RE: M-51 Industrial– Response to City Comments

Please refer to our responses below which address all review comments received from the City of Marysville on September 1, 2023, regarding the M-51 Industrial submittal package. You will find the markup comments listed in the order that they were written followed by our response in *italics*.

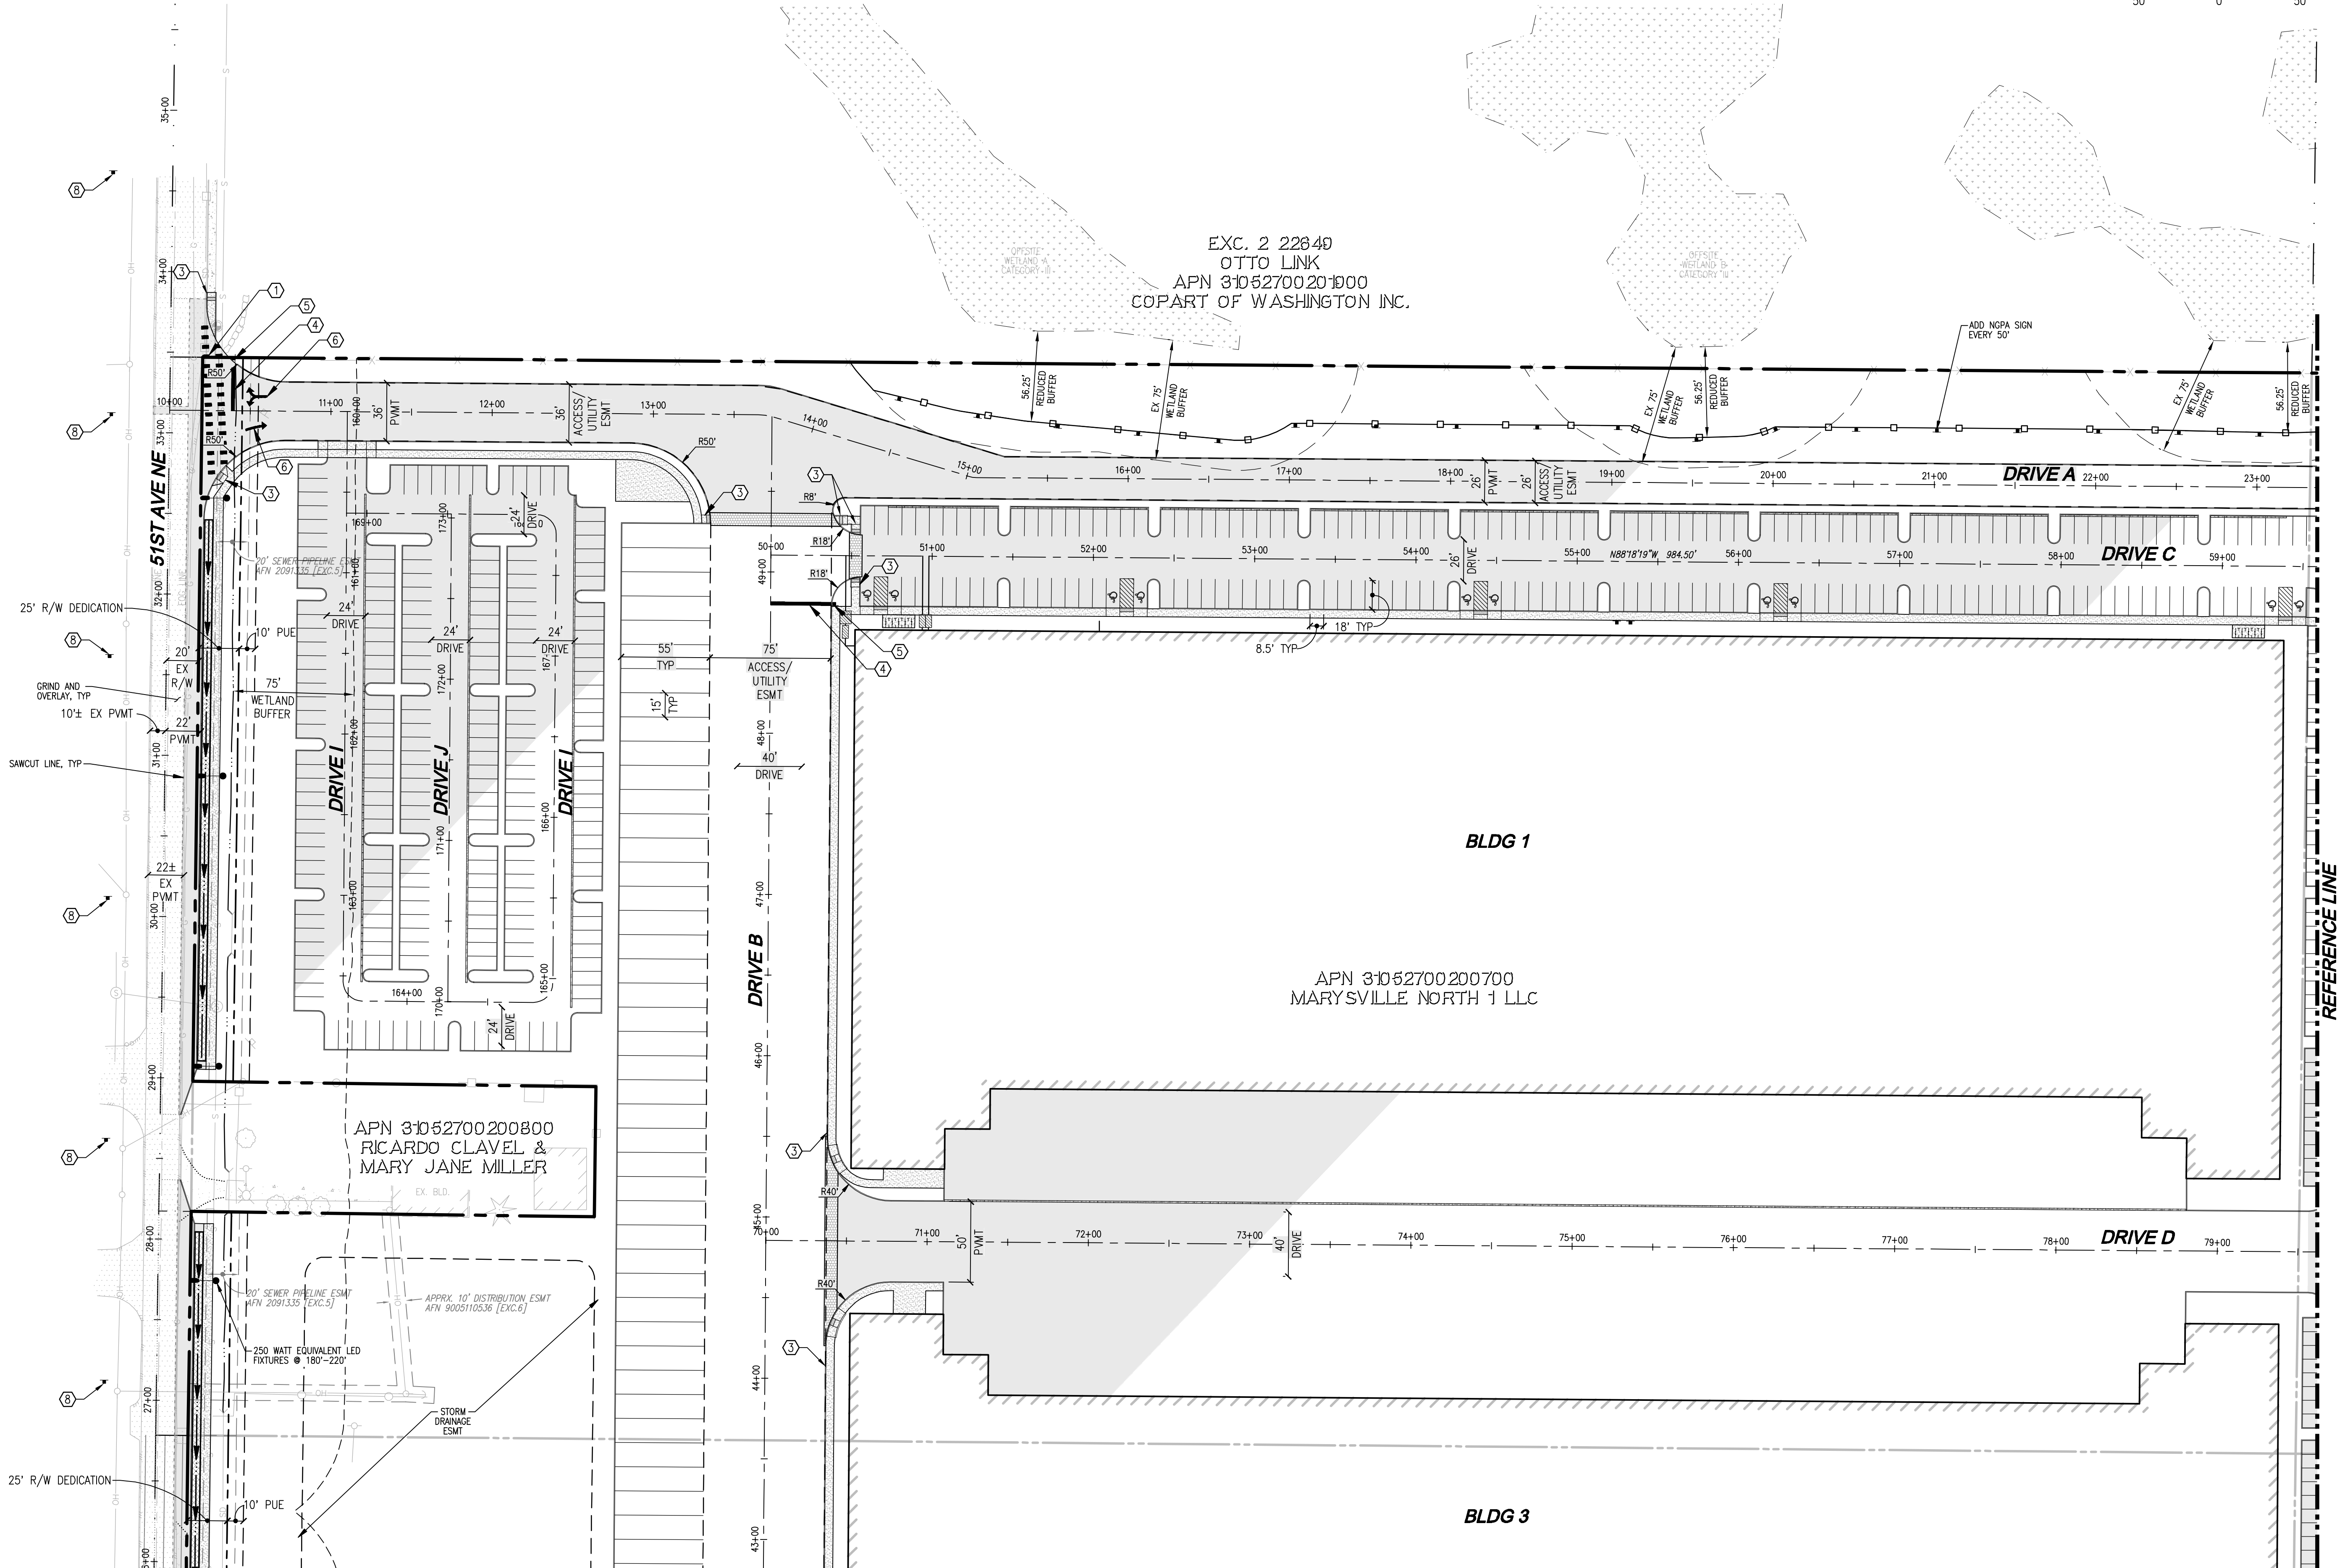
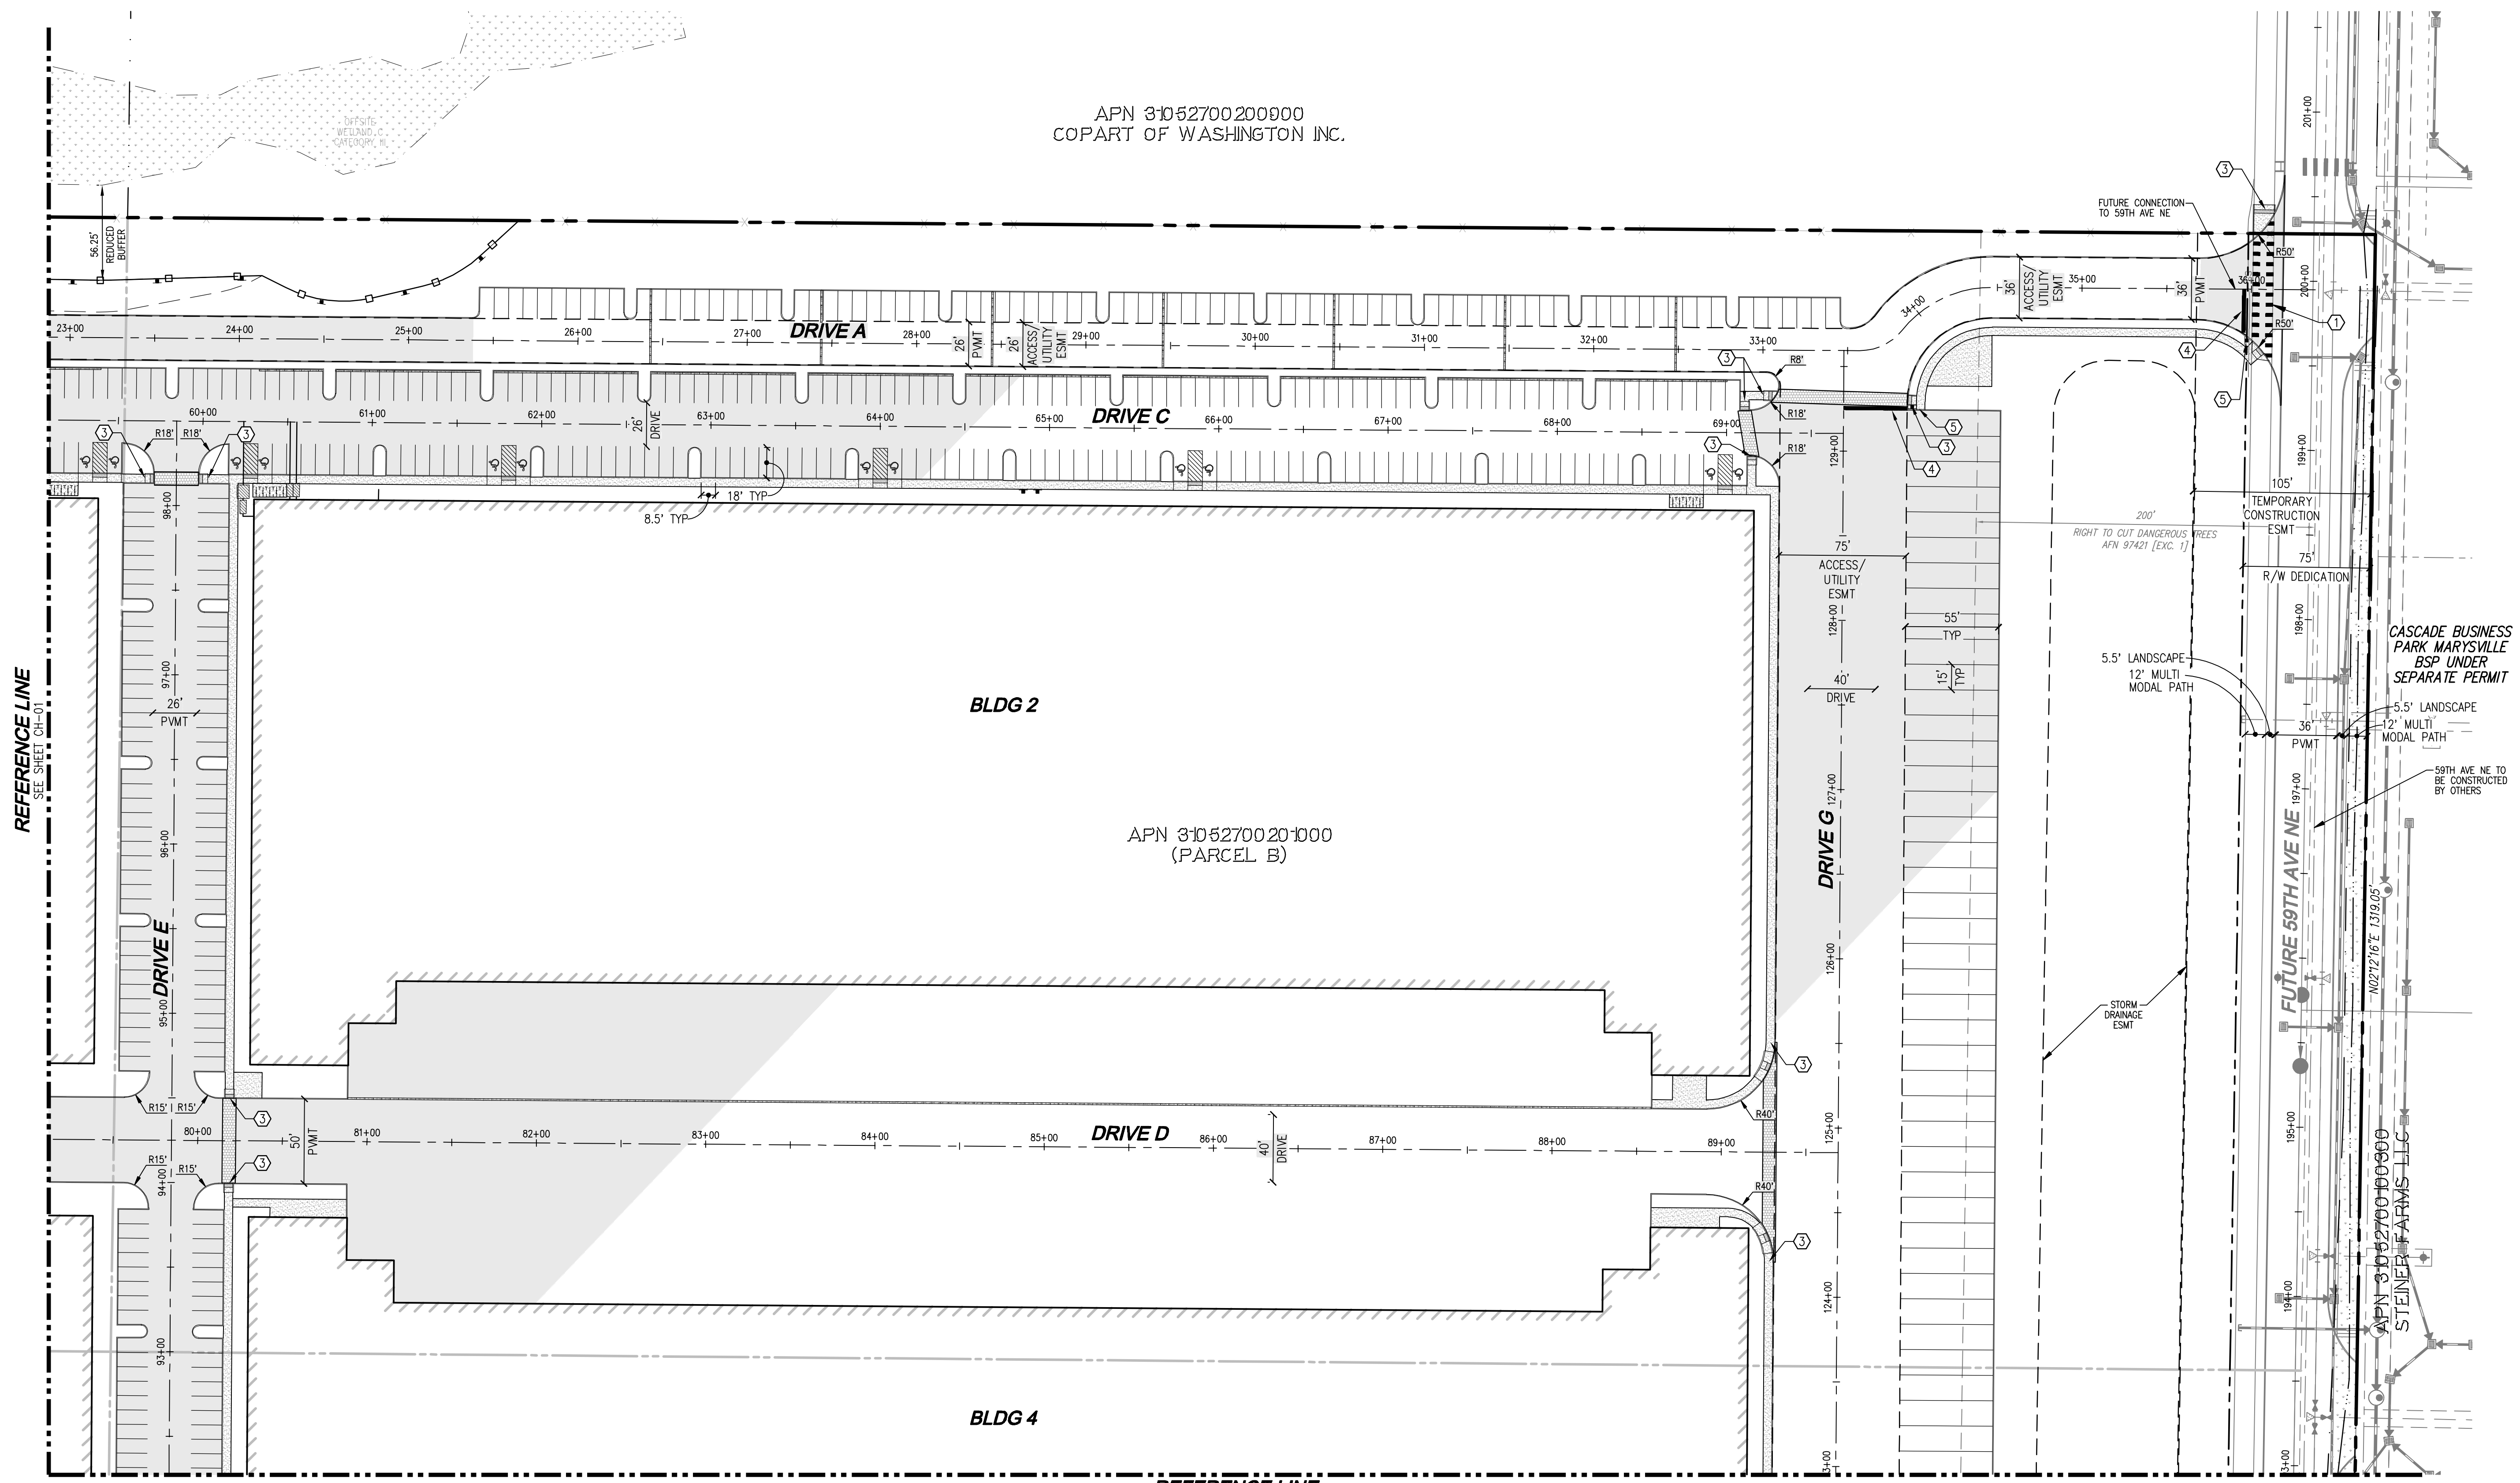
15. Provide auto-turn exhibit demonstrating vehicle and truck traffic can navigate the drive-aisles.

Response: Added Auto-turn diagrams as noted.
